WEST SUSSEX COUNTY COUNCIL CONSULTATION

TO:	Arun District Council FAO: David Easton/Patrick Arthurs
FROM:	WSCC - Highway Authority
DATE:	13 February 2024
LOCATION:	Barnham, Eastergate, Westergate BEW Parcel SC1 Barnham
SUBJECT:	BN/11/22/OUT Outline application with all matters reserved (except for the A29 Realignment) for the demolition of existing structures and mixed use development to provide residential dwellings (Use Class C3), Care Home/Senior Living Accommodation (Use Class E/F2/Sui Generis), a Primary School plus open space, landscaping, drainage and all other associated ancillary works; and realignment of the A29 and early connection to existing A29 including construction of a new road carriageway, junctions and associated infrastructure. This application also lies within the parish of Aldingbourne, affects the setting of listed buildings, affects the character & appearance of the Eastergate Church Lane Conservation Area and affects several Public Rights of Way. This application is the subject of an Environmental Statement. Further information received for the above application which is accompanied by an Environmental Impact Statement. The information was received on 21st

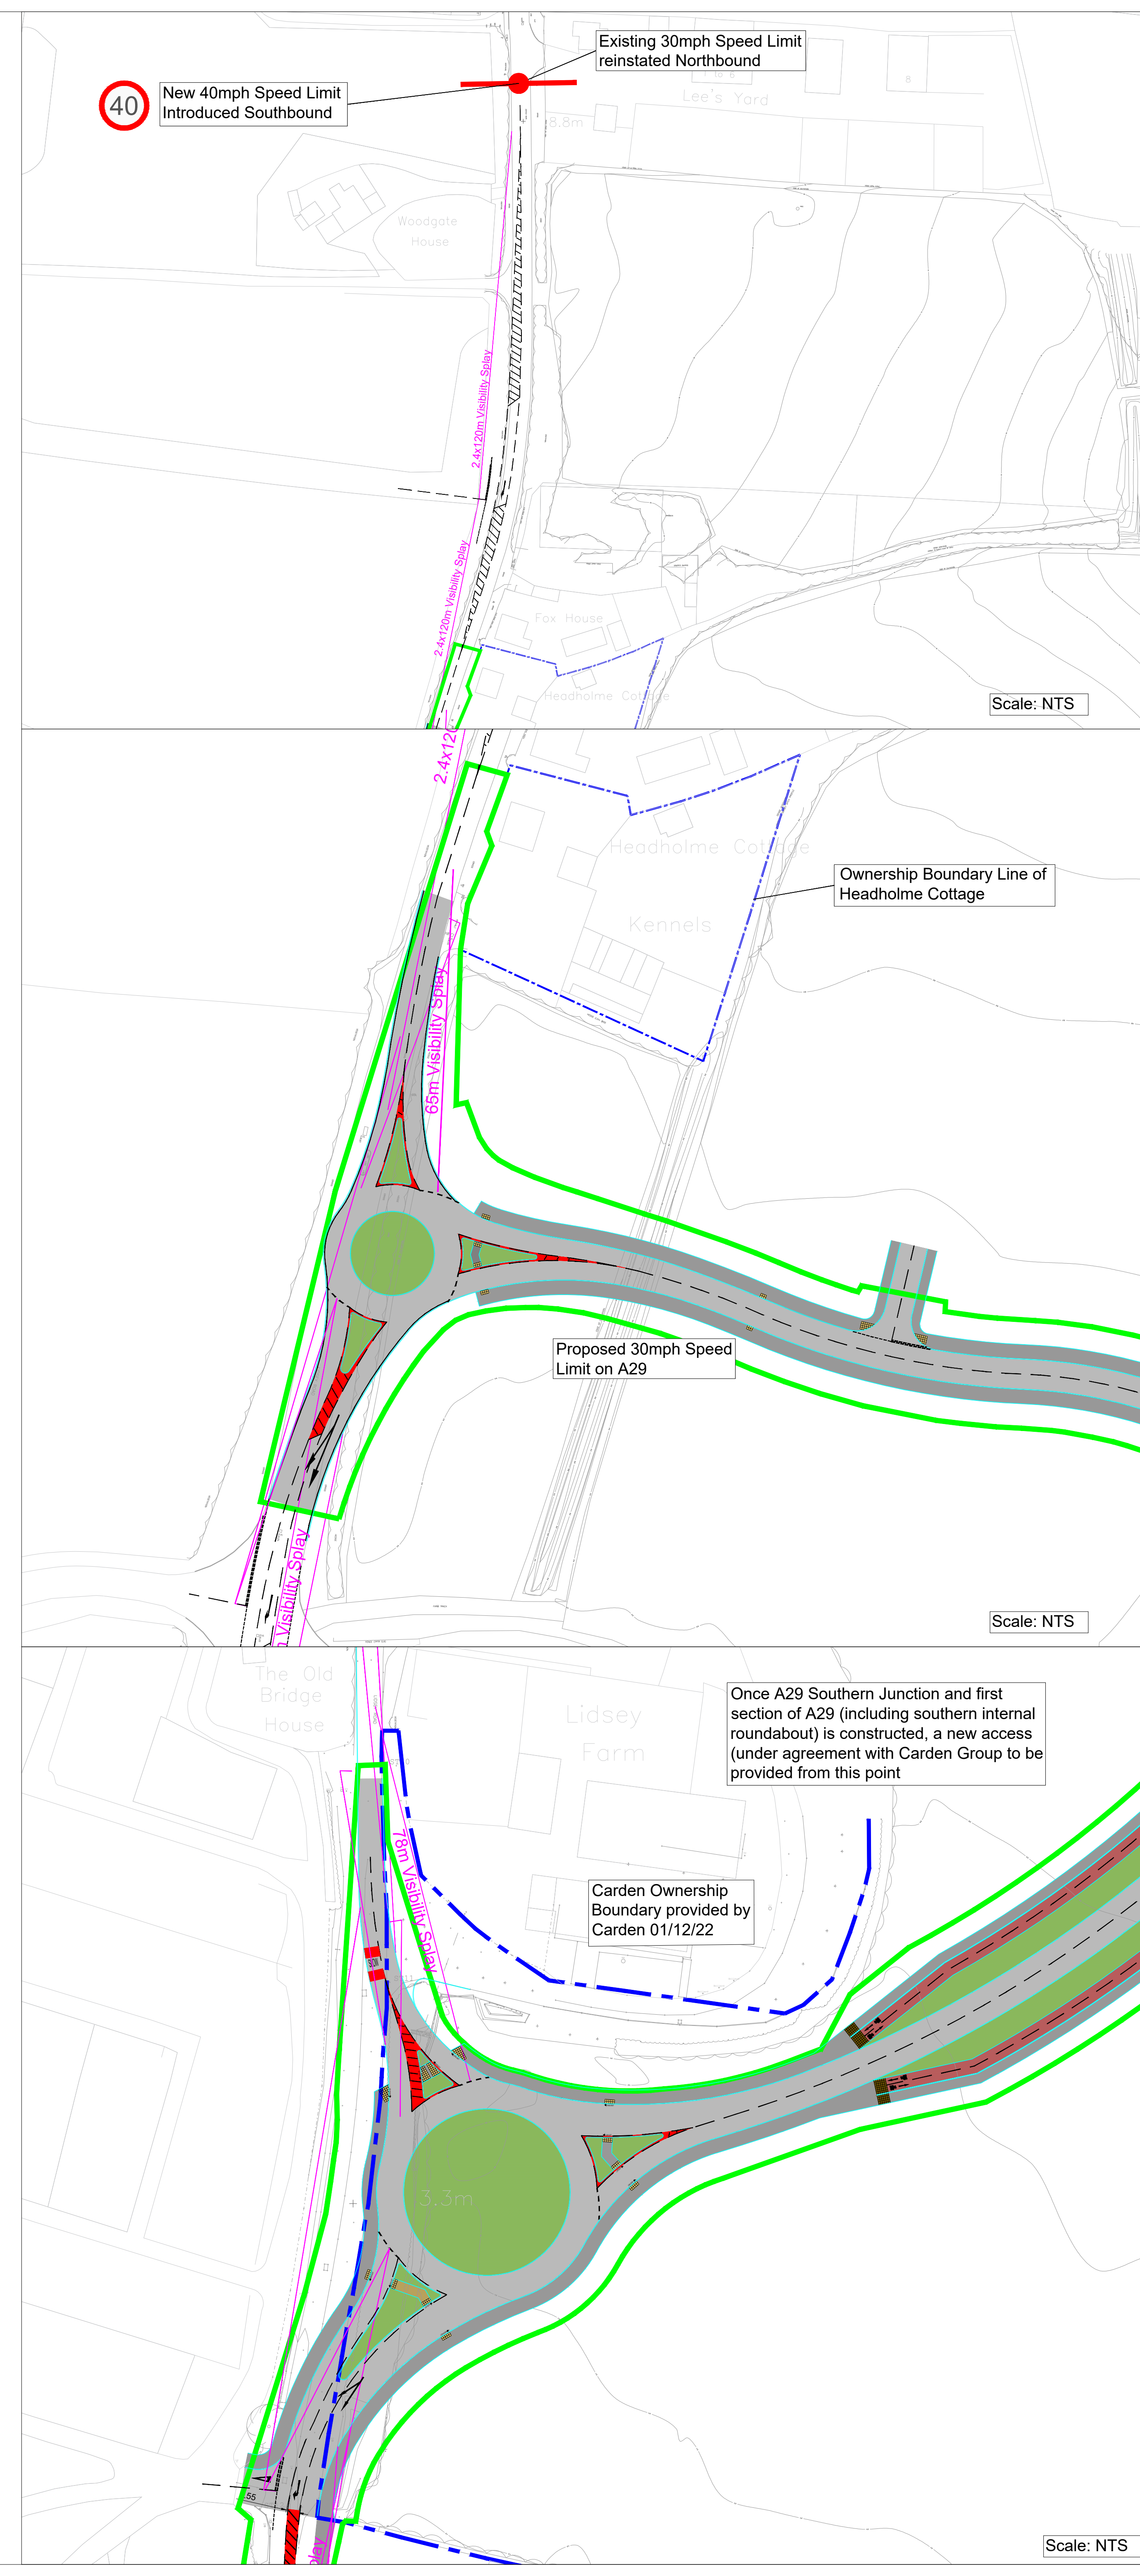
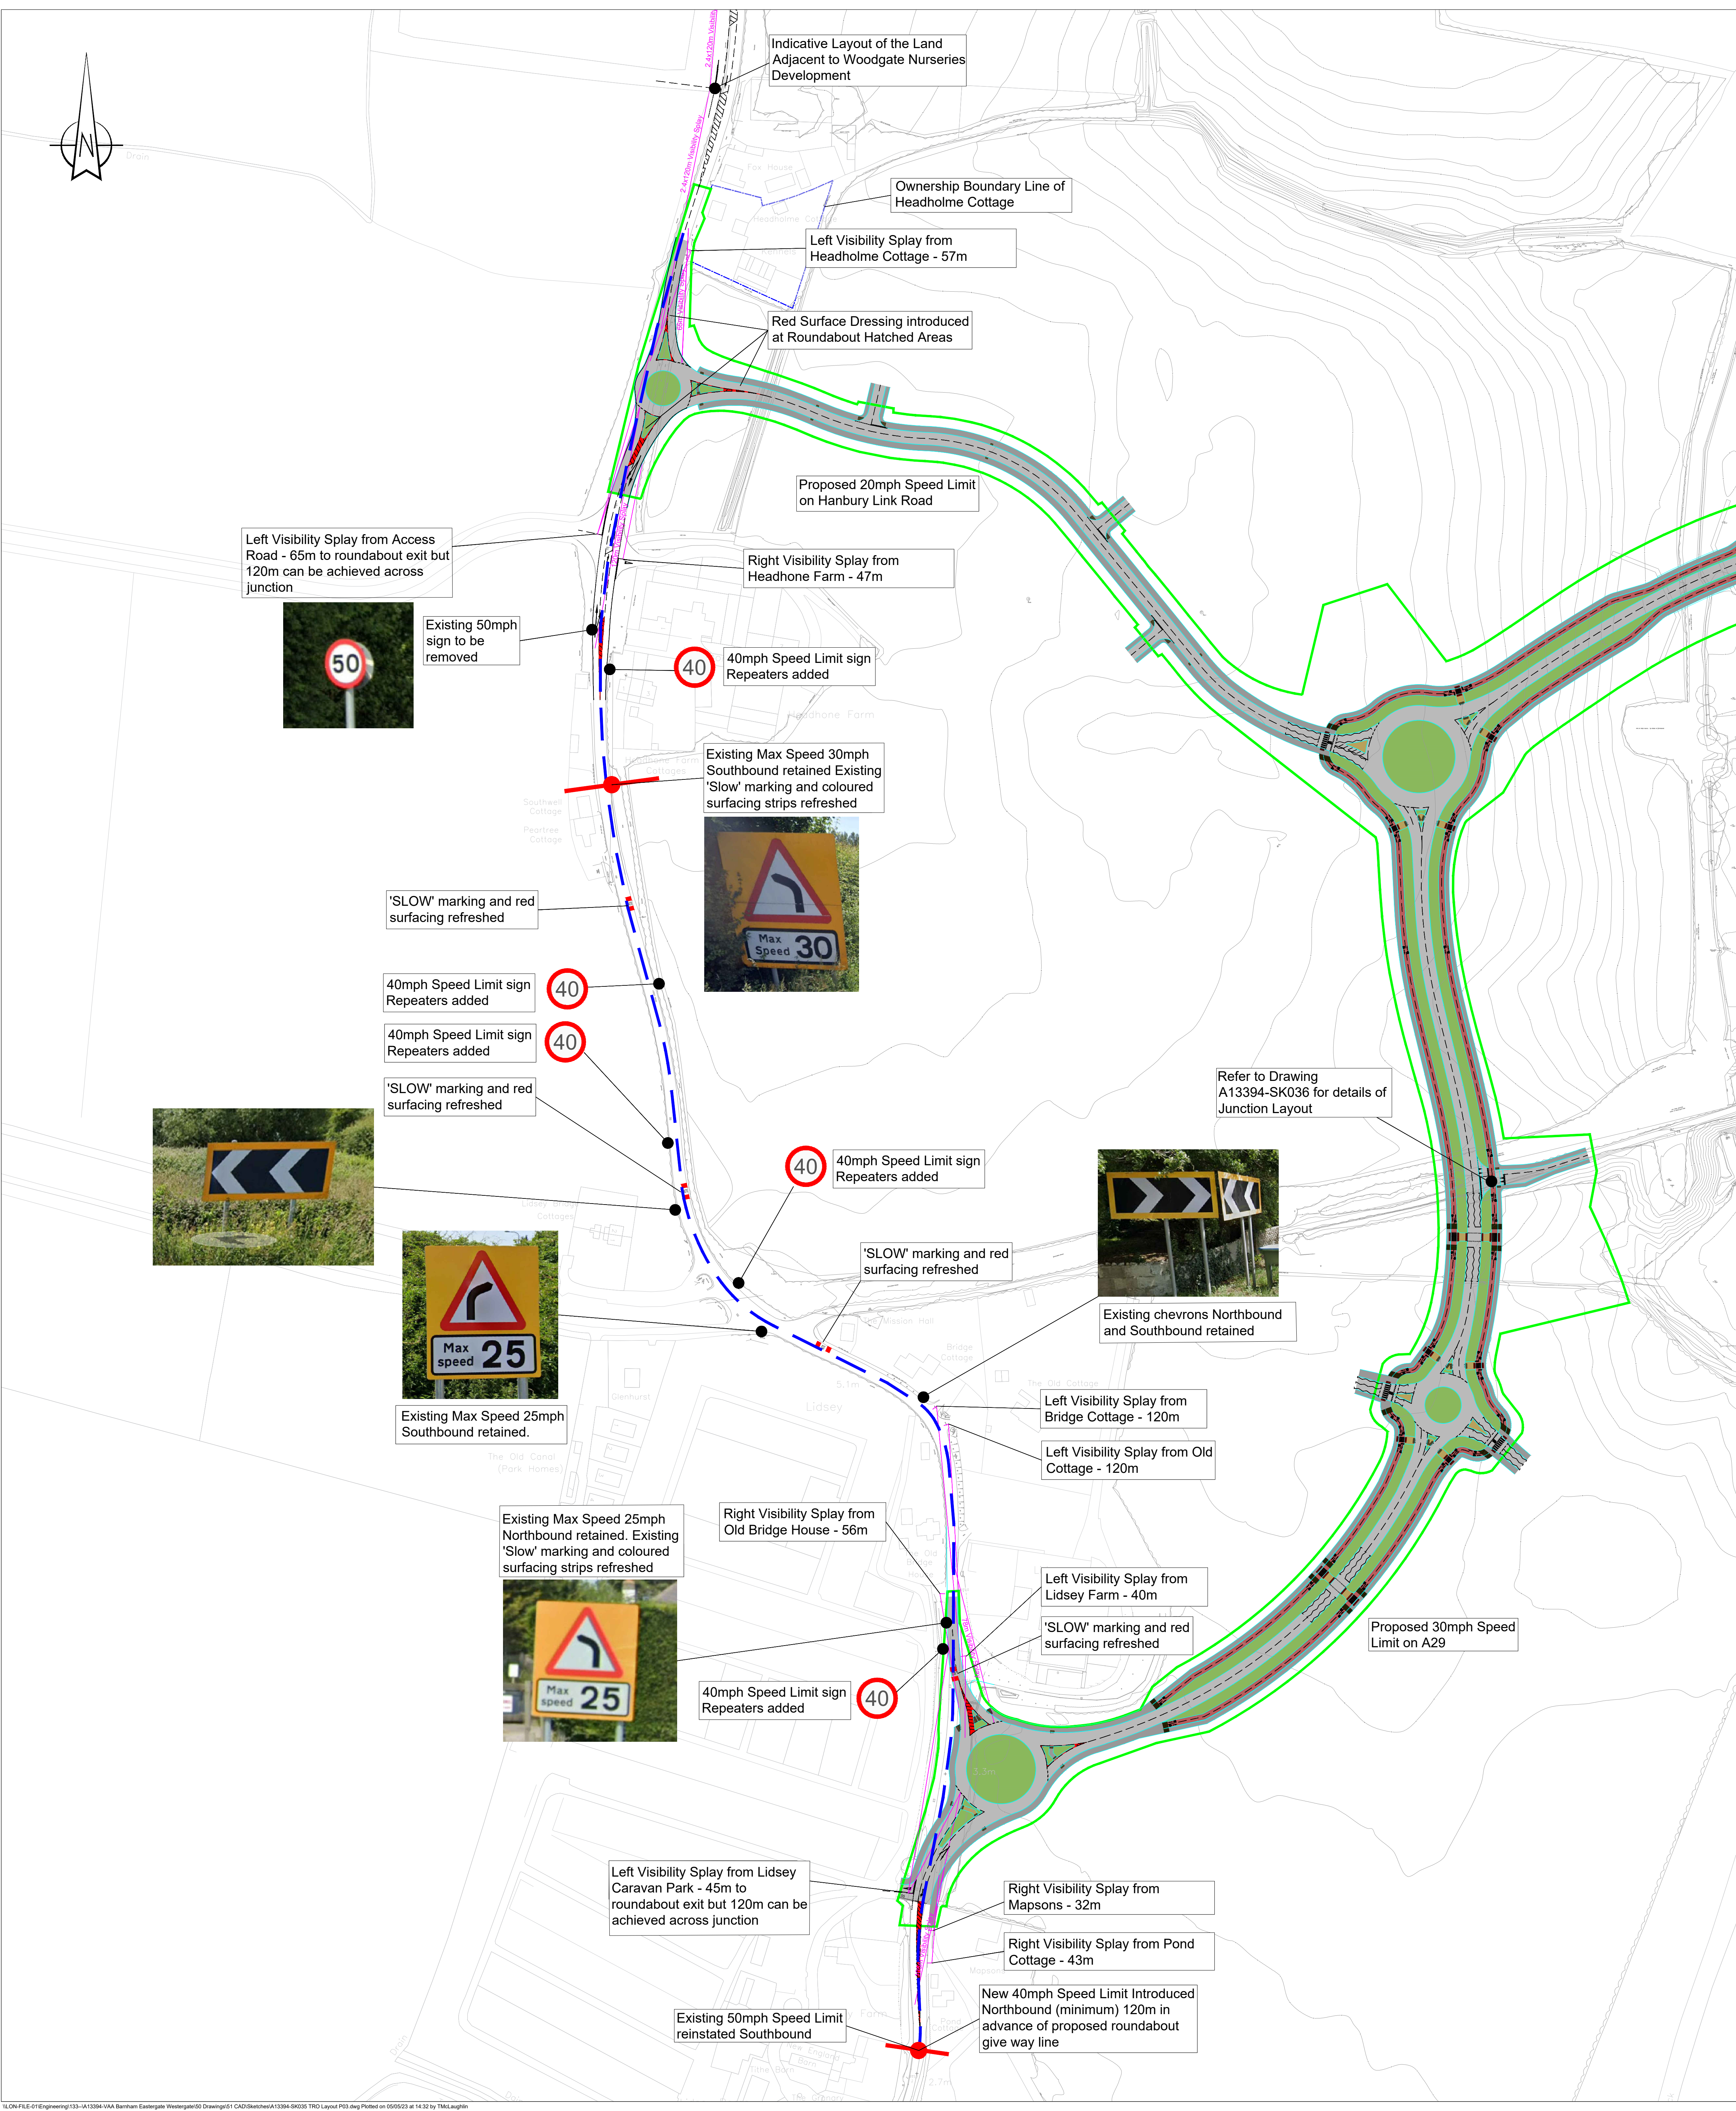
*(*The applicant has provided plans showing the 40mph speed reduction area only running to just north of the Hanbury Link Road roundabout, thereby leaving a section of 50mph speed limit. This would not be acceptable to the Highway Authority and as such, needs to be extended to meet the existing 30mph speed limit where the existing A29 enters the start of the built-up area of Woodgate).*

Off-road segregated foot and cycle paths are proposed to run along the new section of A29 on both sides of the carriageway (although as previously noted, the direction of travel on these paths, as currently shown, is incorrect and need to run 'left-right' and not 'right-left', as shown on the latest submitted drawings). Additional to this, other paths – a selection of pedestrian-only paths, shared foot and cycle paths and additionally under the railway bridge, running through the entire development site – will provide a network of sustainable access (walking and cycling) paths for users of the development.

- i) Provision of segregated cycle paths running parallel to new A29 run the correct way (i.e. left to right etc. – and on both sides of the road) – current plans show the lanes running incorrectly – i.e. right to left
